Our ref: Marulan Quarry (SSD-65146459)

Subject: Request for Additional Information

I refer to Assessment for the Marulan Quarry (SSD-65146459). After careful consideration, I require further information before the assessment can be finalised.

Hollow Bearing Trees

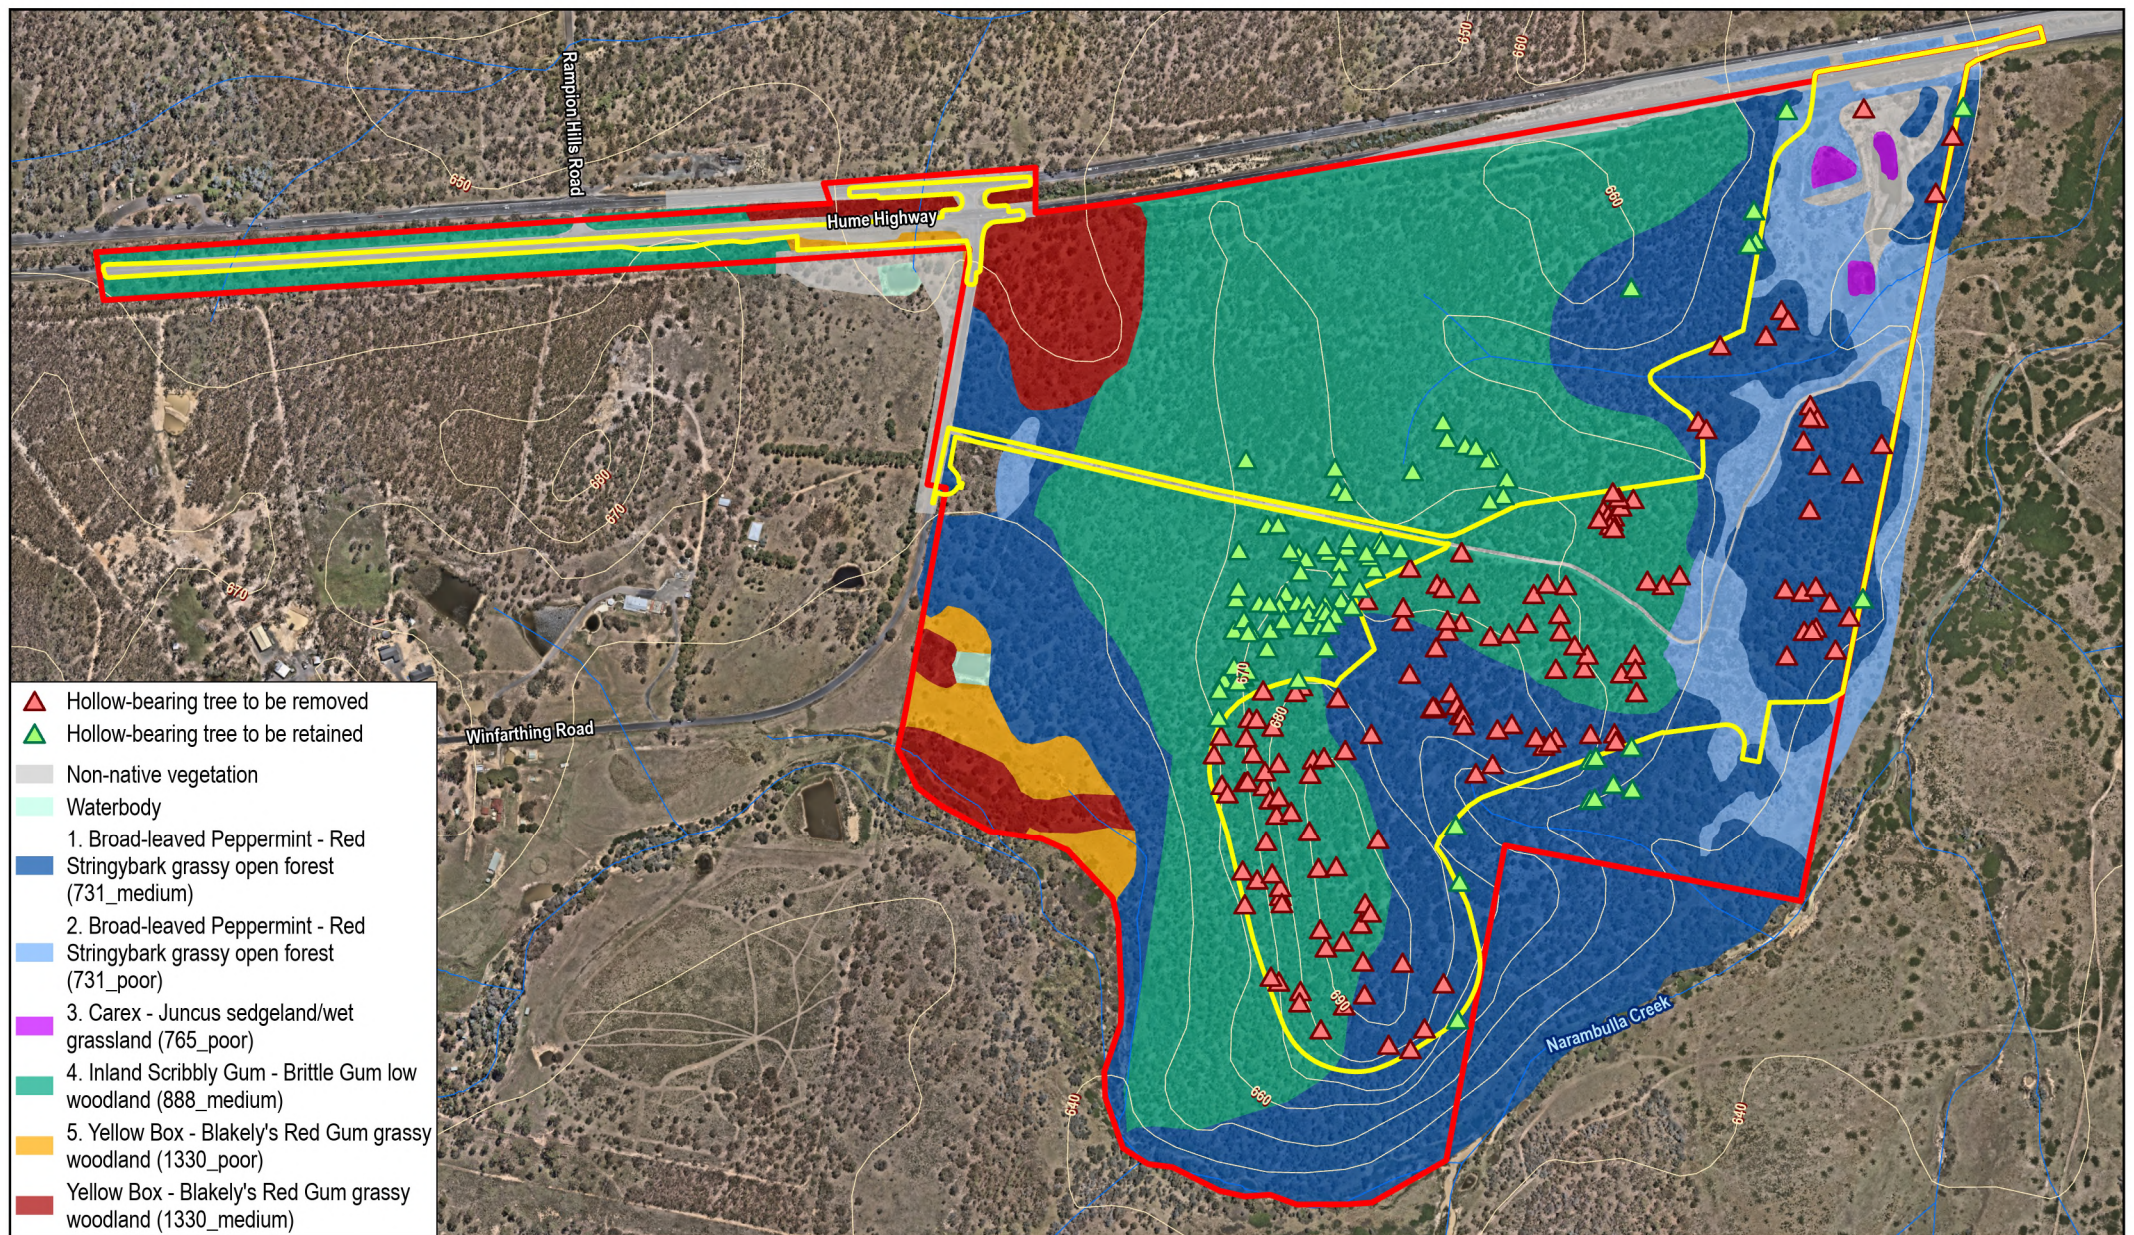
5	Hollow bearing trees I note the EIS, November 2024 BDAR and August 2025 BDAR state hollow-bearing trees are abundant within the study area. However, the total number of hollow-bearing trees proposed for impact is not defined in these documents.	Please provide the total number of hollow-bearing trees the project intends to impact.
6	Hume Highway medium strip closure timeframe I note that the Traffic Impact Assessment states that the Hume Highway medium strip would be temporarily closed for a ‘short period’ while widening and line marking upgrades take place.	Please provide an estimated timeframe for the closure of the Hume Highway medium strip.
